23rd March 2022

RE: Covering Statement for a Variation of Conditions application in relation 21/1777/FUL – Residential development of 2 no. dwellings at Land Off Main Street Norton Disney

Drawing Number
J1601d-PL-12

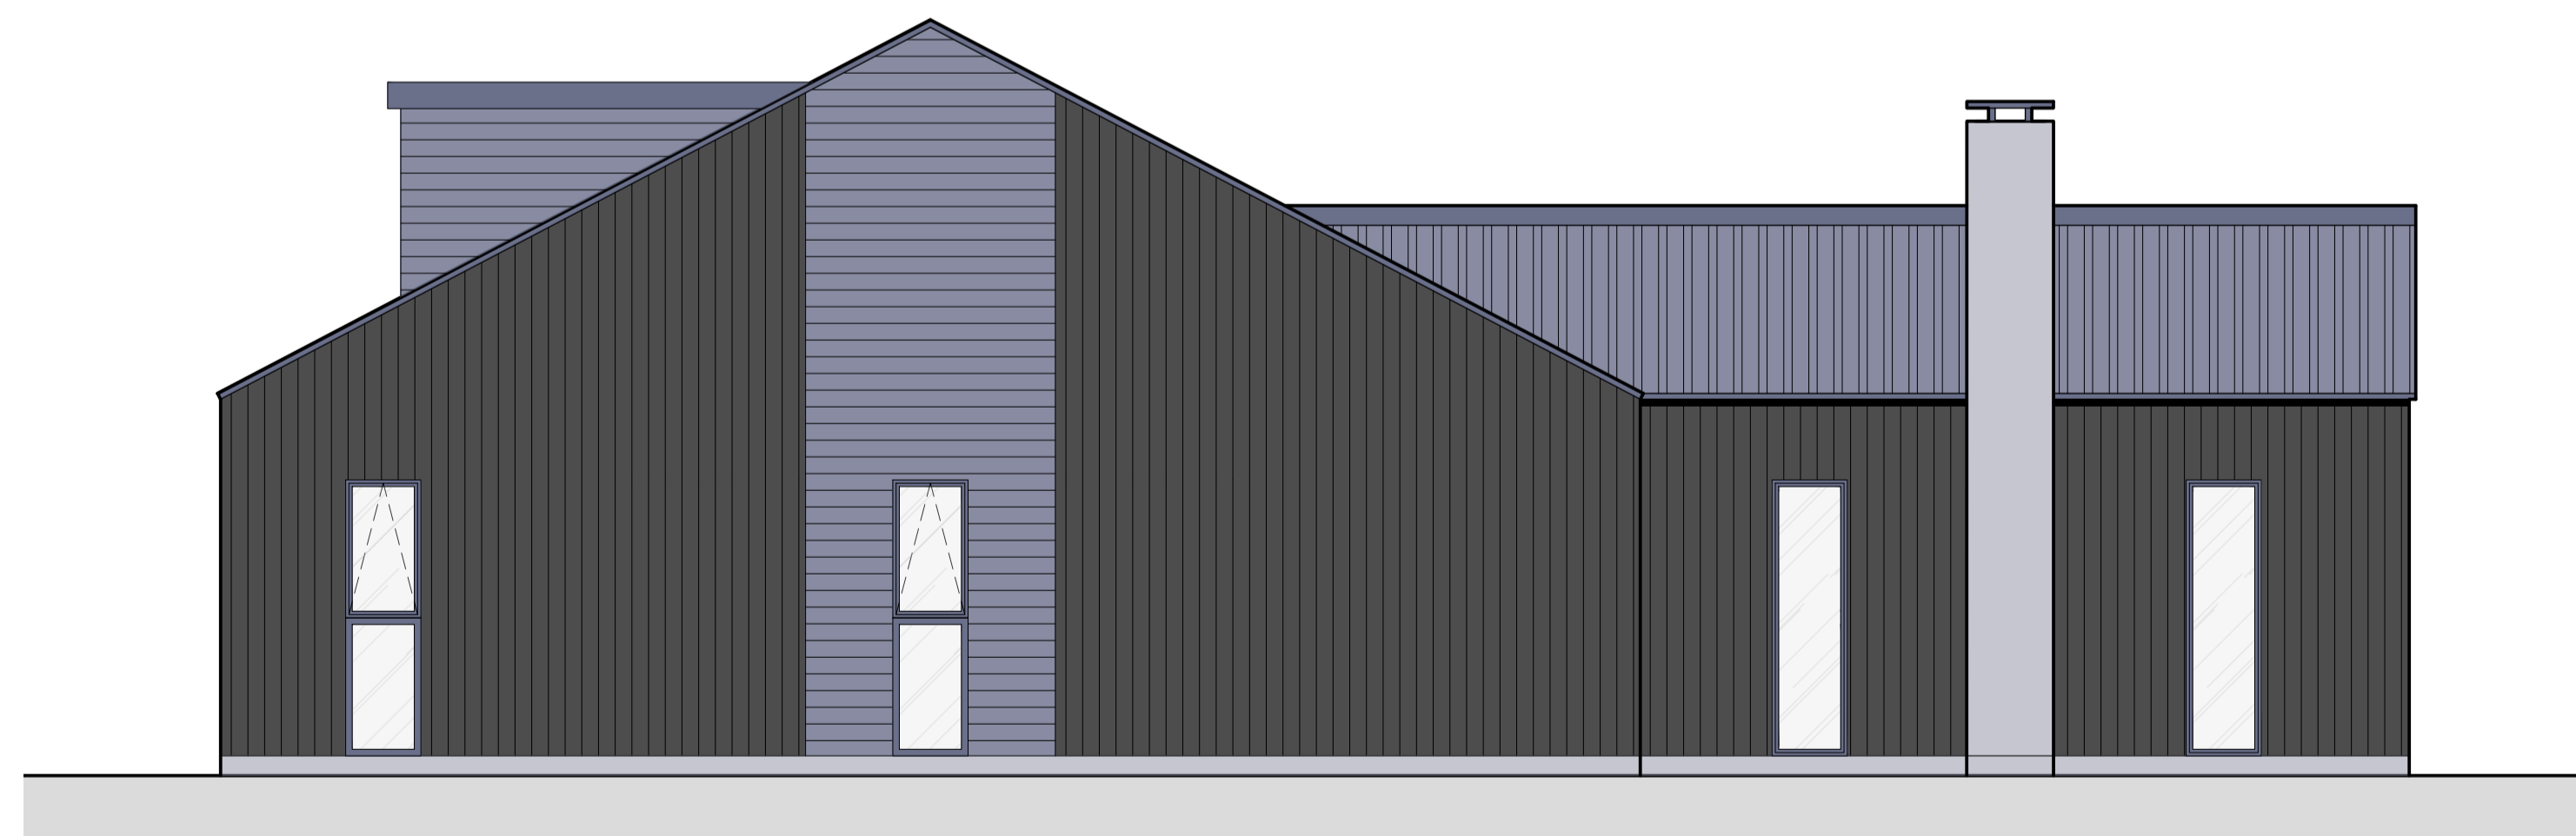
The inclusion of the dormer window and rooflights allow for additional accommodation to be provided to the dwelling, without the need to increase the ridge height or footprint of the dwelling. In doing so the amenity of the neighbouring dwellings remains unaffected.

In standard amenity requirements, windows are deemed to be 'facing' if they both fall within a pair of 45-degree cones drawn from the middle of the 2 windows. When this is drawn from the dormer window closest to 'The Chestnuts' no windows are within this area. No part of the dwelling falls within this area. As a result, the amenity of the occupants of 'The Chestnuts' is unaffected by this amendment.

- Addition of one flat roof dormer on the principal elevation which sits below the approved ridge height on each semidetached dwelling to allow natural light and ventilation to the first-floor bedroom

- Addition of two rooflights on the principal elevations on each semi-detached dwelling to allow natural light into the landing and ensuite

Drawing Number
J1601d-PL-11

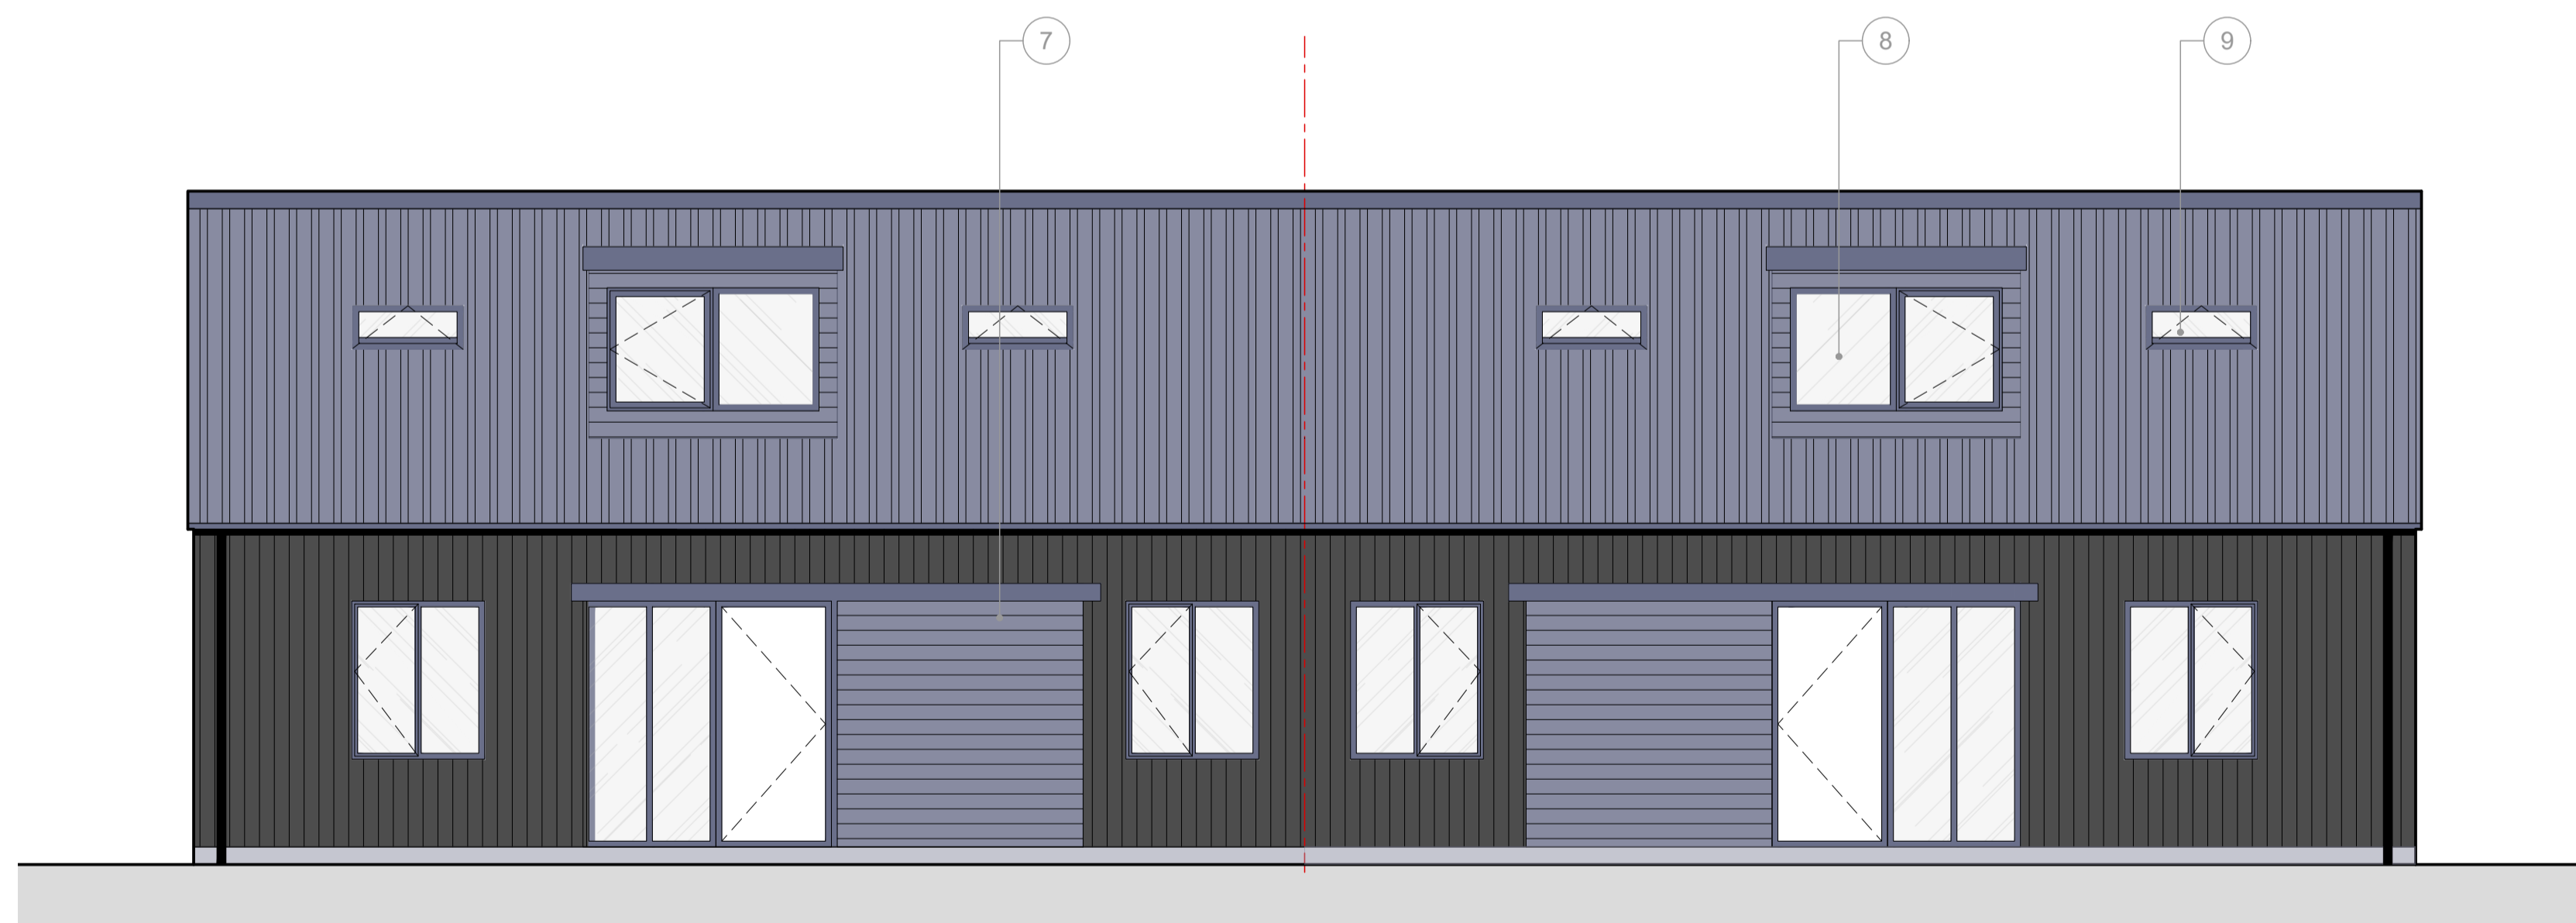
The VARCON submitted includes for a dormer window and two rooflights on each dwelling, allowing for a first floor to be added to the property. The only other changes are alterations to the internal layout of the dwelling and minor amendment to the windows for bedroom 3 on each dwelling.
